PORTLAND MAINE

December 17, 2012

RE: Maritime Landing Project (Federated Companies) – Plan Comments

This letter is intended to provide City staff comments on the Maritime Landing concept plan presented at our meeting with the Federated development consultant team on December 5th. We received one copy of the plan at that meeting while additional copies were distributed to the City on December 10th. The reviewed plans were prepared by DeLuca Hoffman Associates. Public Services notes that the plans are conceptual so comments are very preliminary until more detail can be provided. Also a soil analysis study is expected to be undertaken shortly which may further inform our initial comments. Public Services may have additional comments beyond those outlined in this letter, so we will forward review comments to you as soon as we receive them. Note that these comments are based on that version of the plan and do not reflect any changes you may have made to it since that time that may respond to some of these comments.

Drawing file: FST - Site Plans Revised 01-21-2015 / C-7.12 Bayside Trail Retaining Wall Retaining Details and Abuter Options.pdf

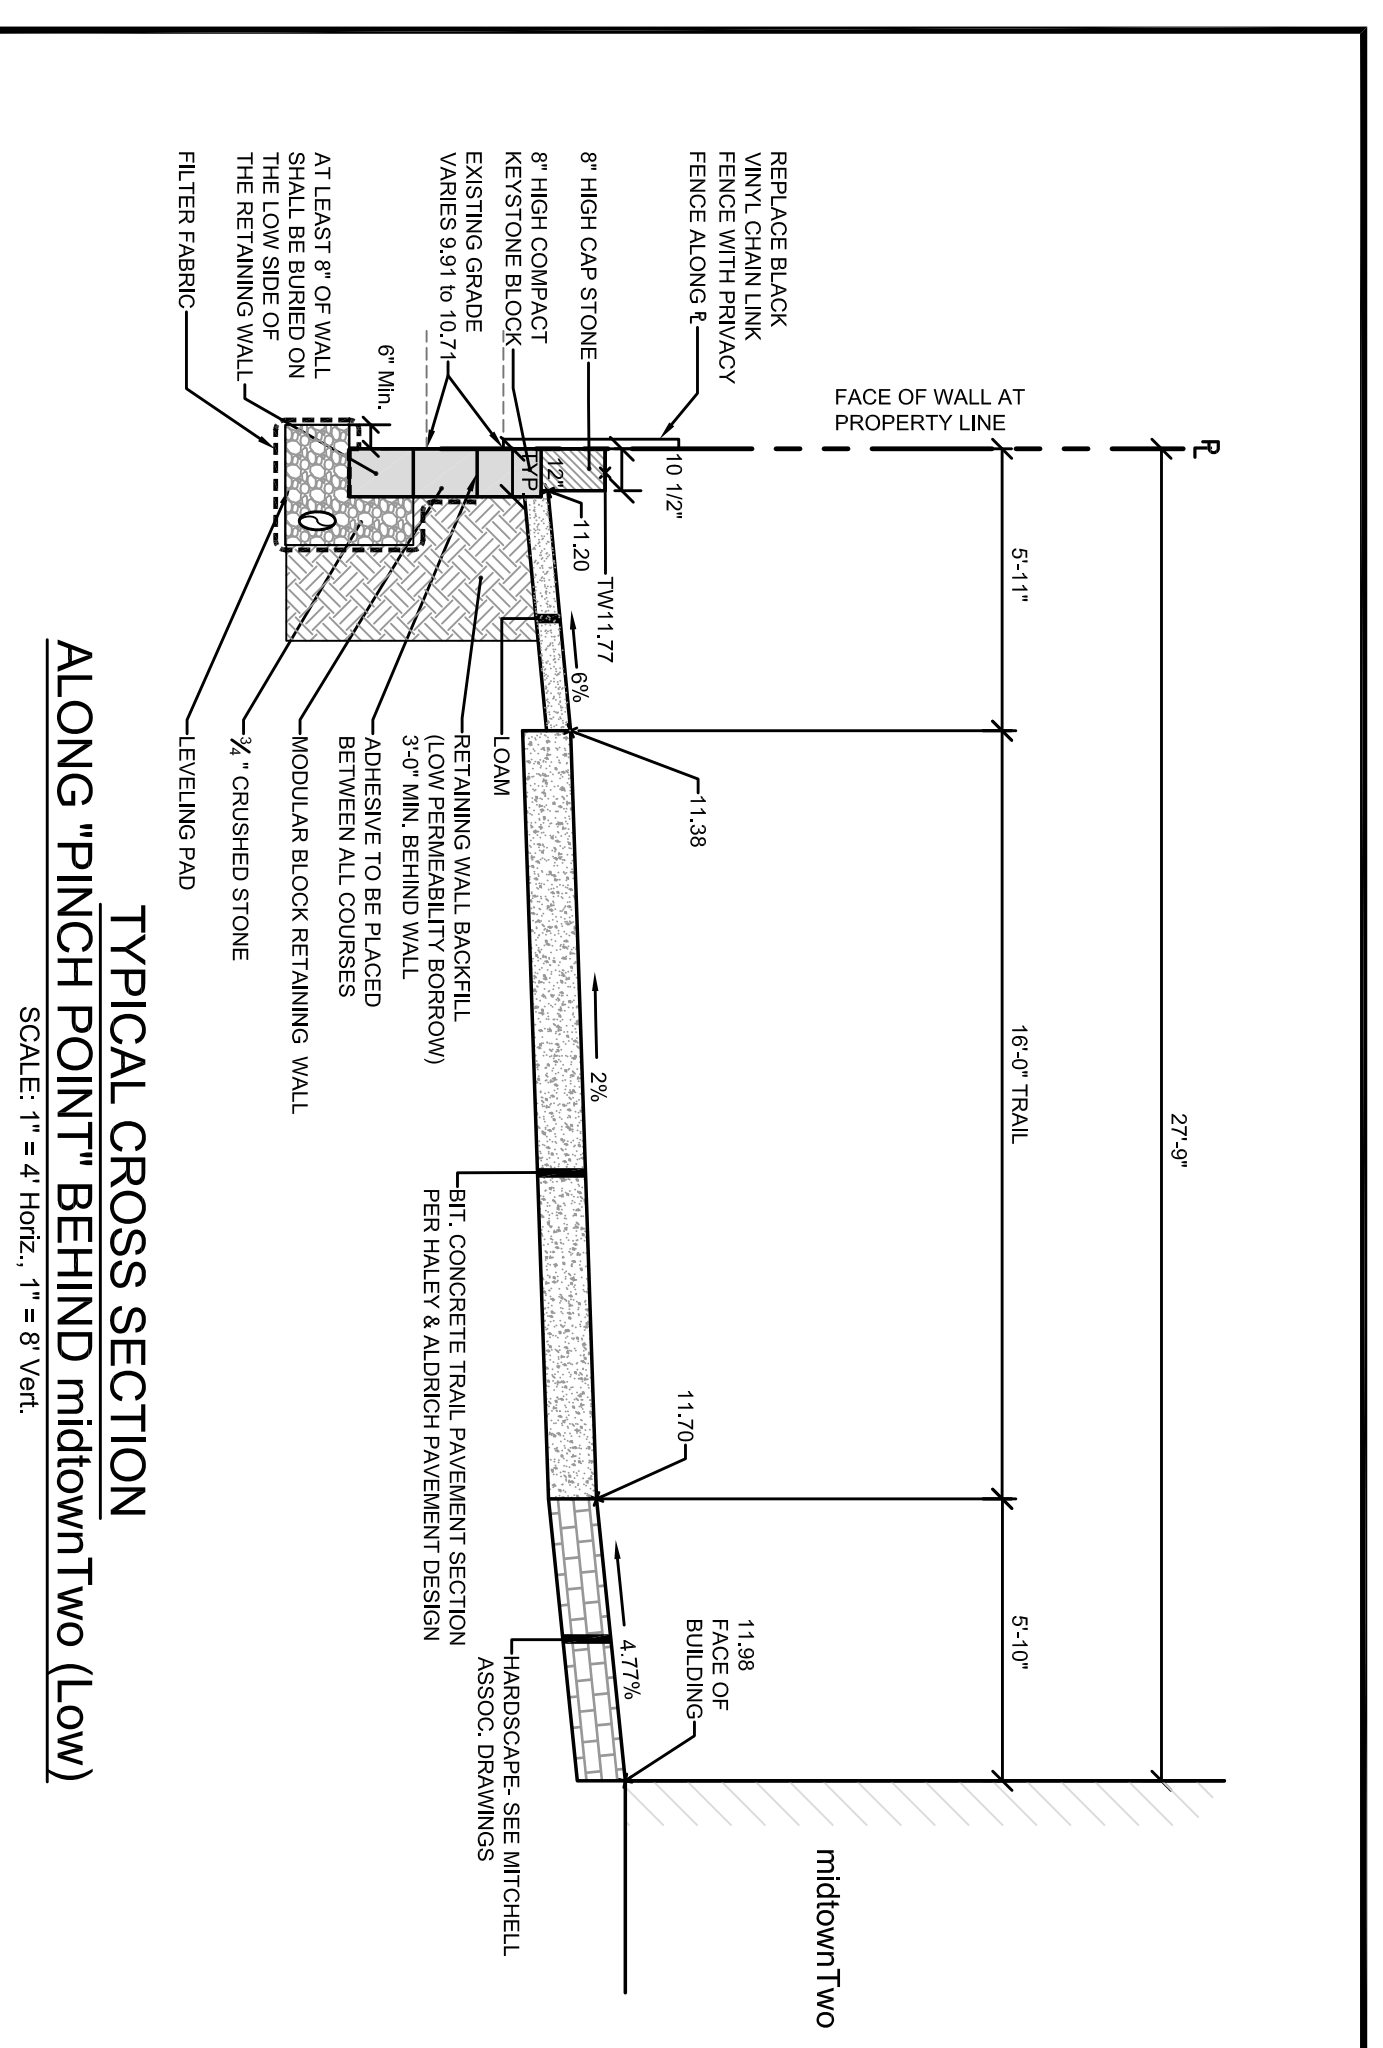
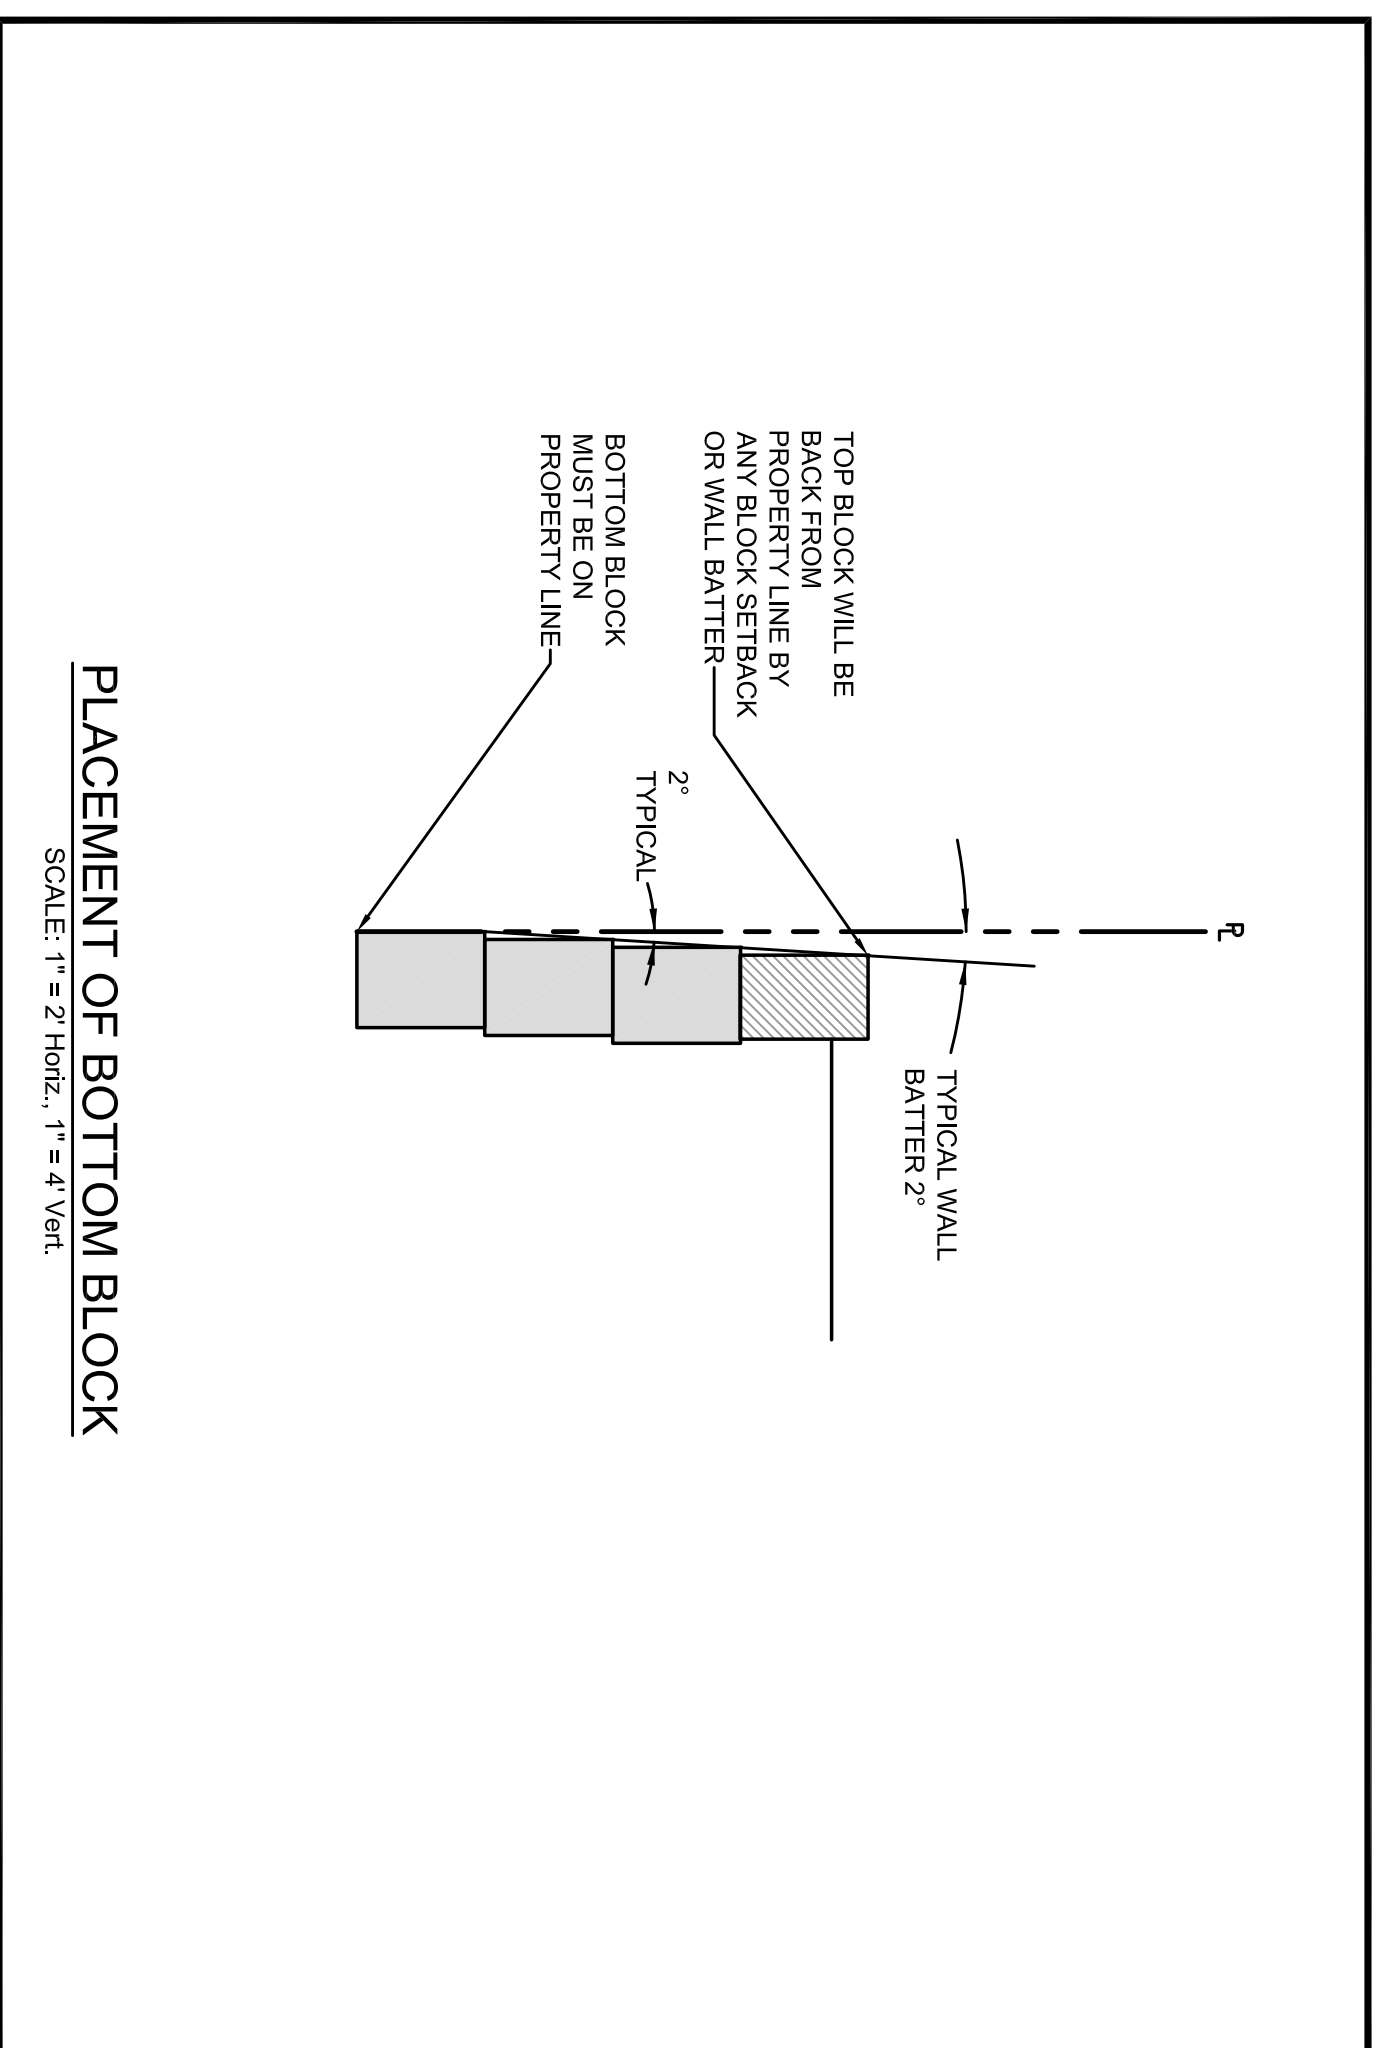
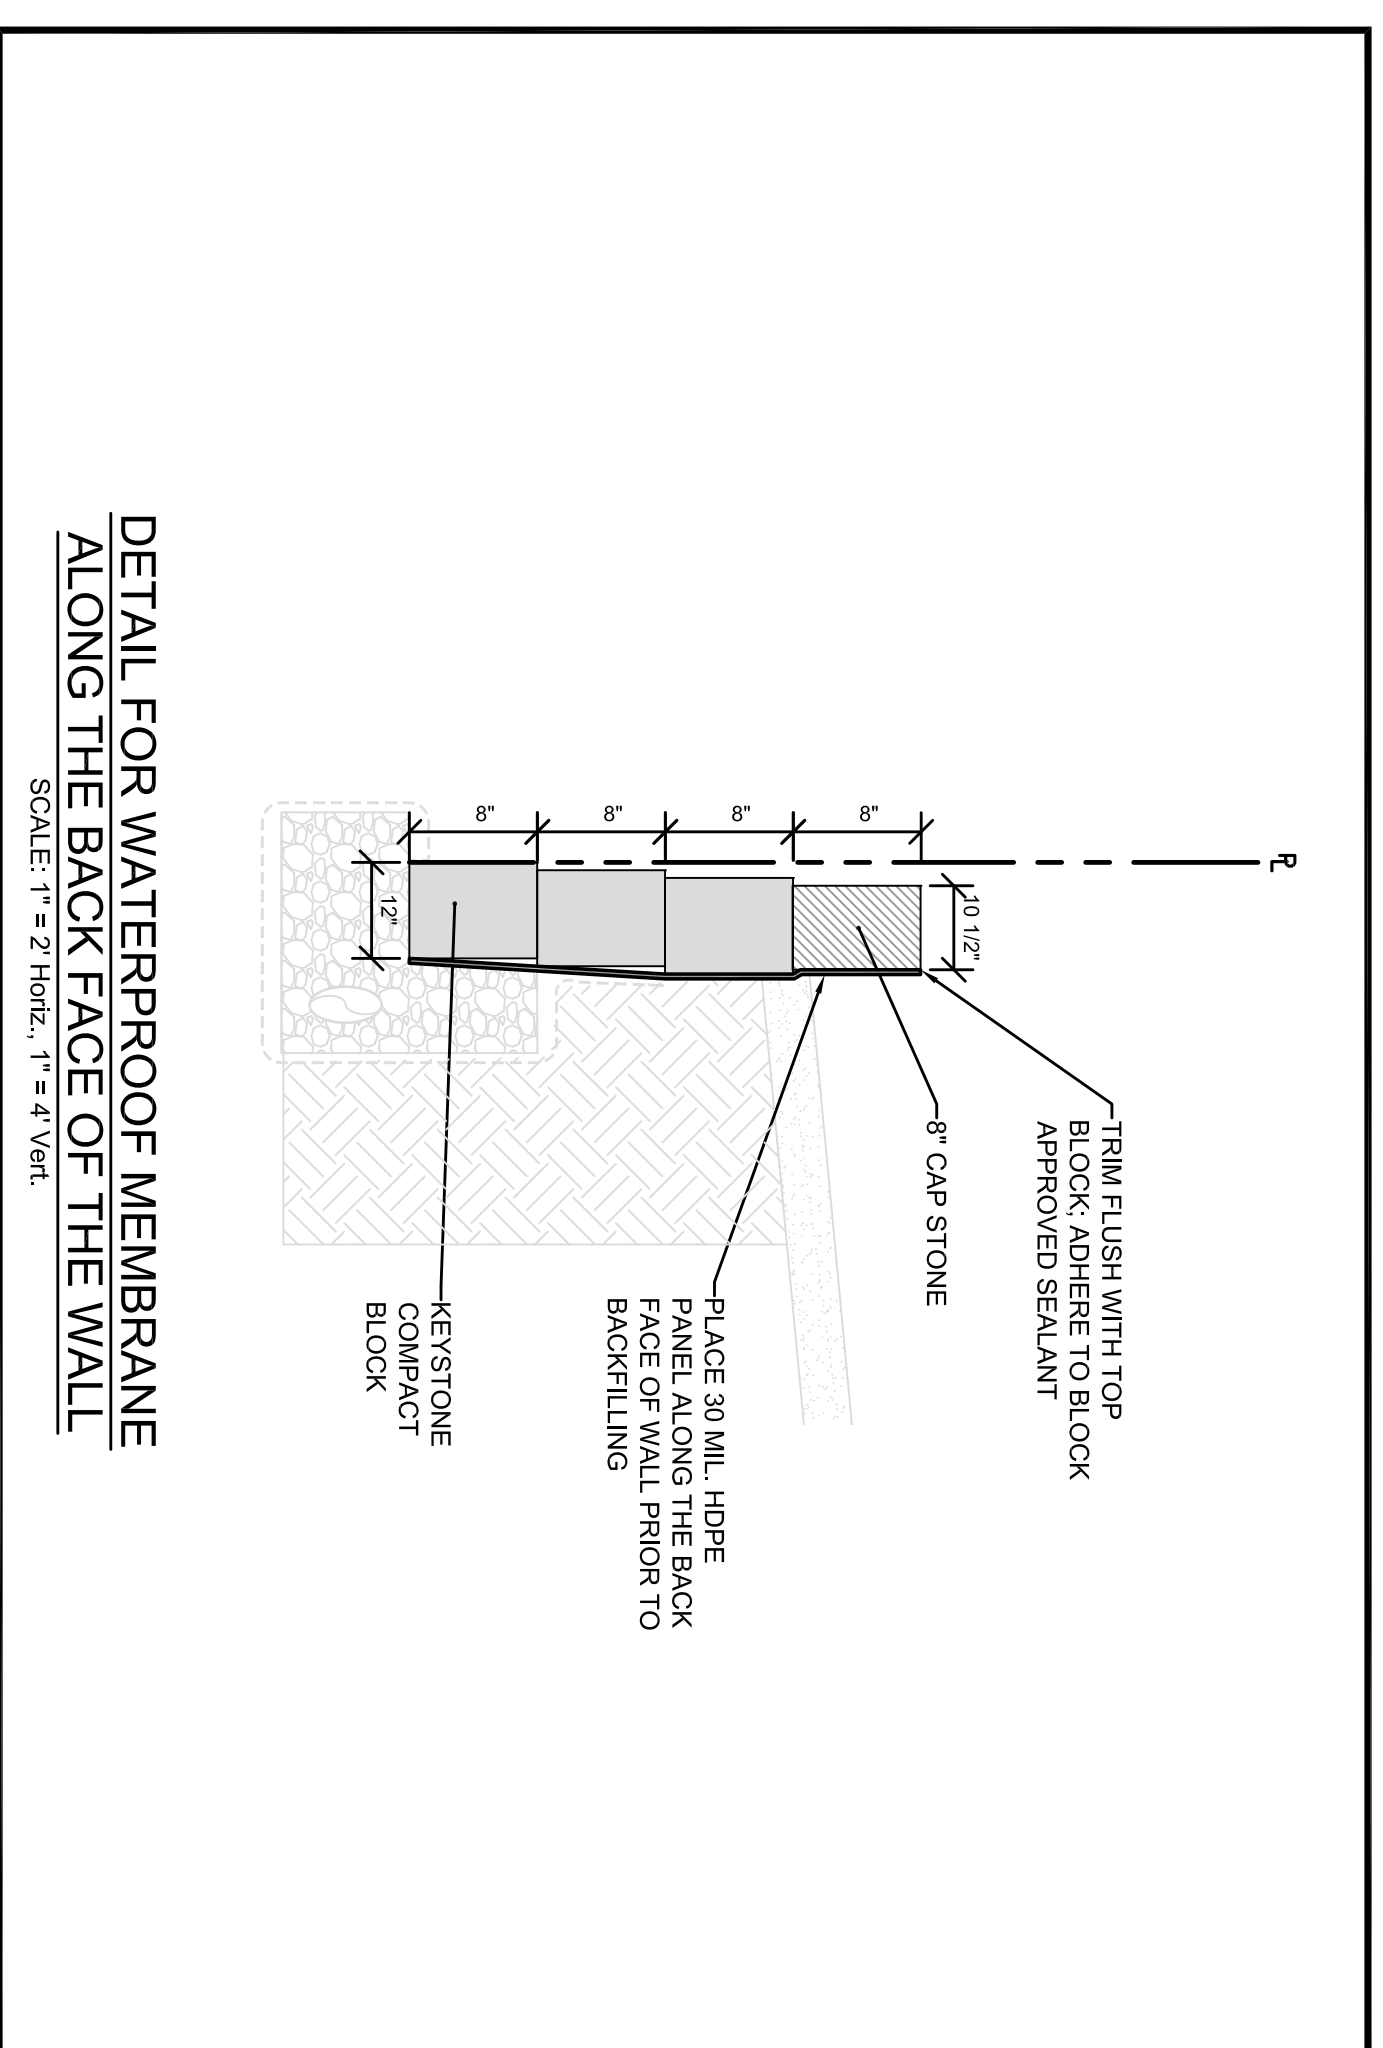
3. **Bayside Trail Retaining Wall:** The retaining wall shown along the northerly property line of the trail adjacent to the DHS/Planet Fitness parking lot is very close to the property line. Any grading or temporary construction easements that may be required from the abutting property owner will likely be problematic. The property owner has had extensive conversations with the City in the past concerning trail construction activities undermining the stability of the fence and or the adjacent slope. Also how high is the proposed retaining wall and what type of material are you considering for the wall? The City recommends that the preferred design not include a retaining wall.
4. **Shifting of Buildings into Trail Space:** The revised plan shows shifting proposed buildings over the subdivision lot lines and into the trail space.
